Subject: FW: Reconsult on planning application. Eisai Europe Limited, European Knowledge Centre, Mosquito Way, Hatfield, AL10 9SN. 6/2022/1853/MAJ

From: Simon Richards1 <Simon.Richards1@hertfordshire.gov.uk>
Sent: 22 March 2023 17:07
To: David Elmore <d.elmore@welhat.gov.uk>
Cc: Ecology <Ecology@hertfordshire.gov.uk>
Subject: FW: Reconsult on planning application. Eisai Europe Limited, European Knowledge Centre, Mosquito Way, Hatfield, AL10 9SN. 6/2022/1853/MAJ

60681916-ACM-XX-XX-DR-L-006003

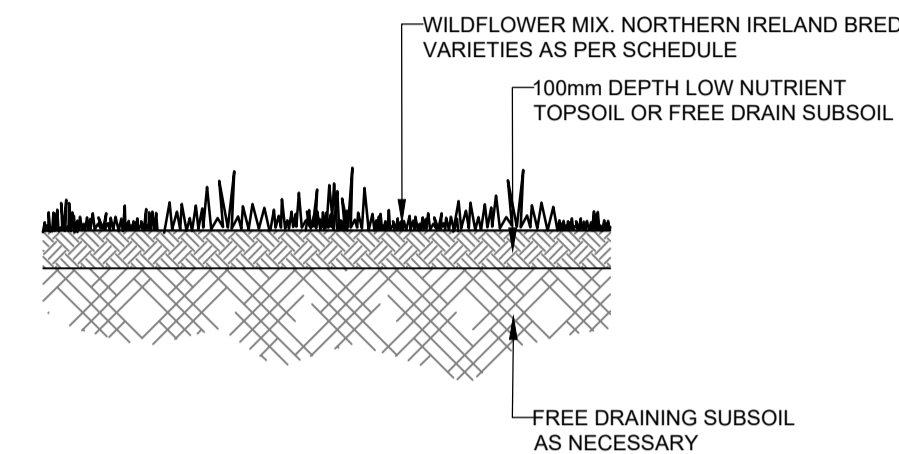
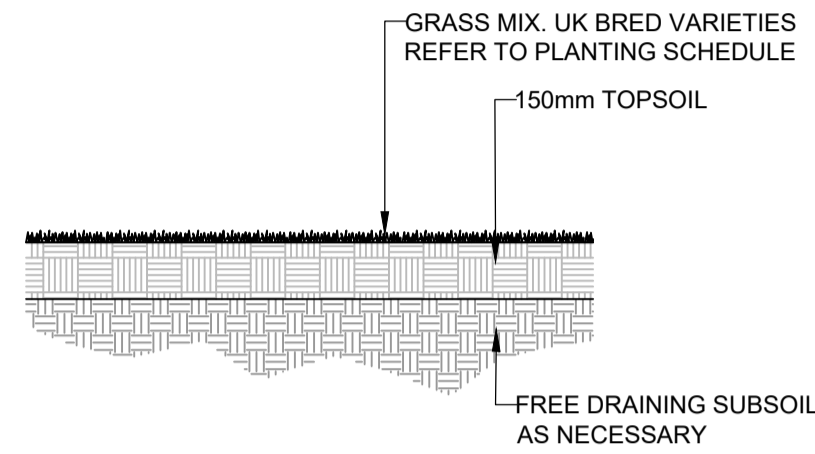
The Metric 3.1 spreadsheet submitted shows a net loss of -1.61 Biodiversity area units or a loss of -33.89%. and that the trading rules have not been met. The BNG report proposes that a BNG of >0% can be achieved by a combination of onsite and offsite measures. On site it is proposed to change the proposed grasslands to other neutral grassland and to substitute five of the currently proposed on site 'Urban trees by larger specimens to achieve an uplift of 0.73 BU. Offsite measures within the surrounding business park, on land also in the applicants ownership, are proposed to meet the remaining loss. This involves improving three areas of modified grassland to other neutral grassland and the planting within them of 4 additional medium sized Urban trees to achieving an overall net gain of 0.78 BU(0.87%). I support these measures, but cannot at the moment confirm the calculations as the supplied metric does not include any of these proposed measures. Consequently, I advise that the submitted metric should be updated and a Landscape and Ecological Management Plan provided showing how all ecological enhancements and a biodiversity net gain of 0.78 BU(0.87%) will be achieved and maintained for a period of 30 years. I advise this Landscape and Ecological Management Plan is secured by Condition with the updated metric, demonstrating these values and compliance with the trading rules, is submitted either prior to determination or as a requirement of the Condition.
